File No: 2013/025662  
Our Ref : R/2009/3/C  
Your Ref: MP 09\_0051 MOD 3

**RE: Section 75W request to modify the Project Application for the Centre of Obesity, Diabetes and Cardiovascular Disease (CODCD), University of Sydney**

FIGURE 7 – PROPOSED S75W PLAN

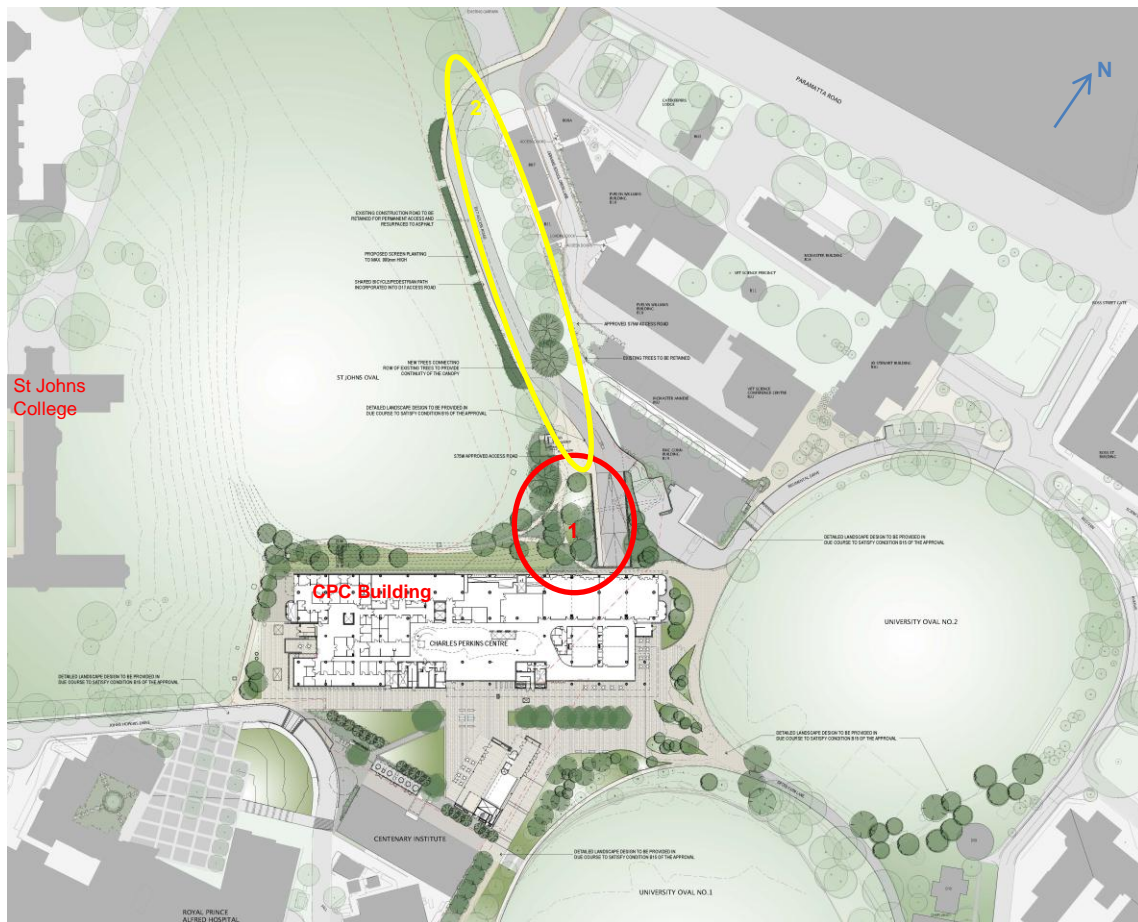
It is noted that Condition B15 requires the provision of a landscape plan, and this should incorporate the proposed tree/shrub plantings.

The existing concrete crossing is in poor condition with a cracked surface that likely to deteriorate under increased persistent traffic load. It is recommended that the crossover be reconstructed and the following condition imposed:
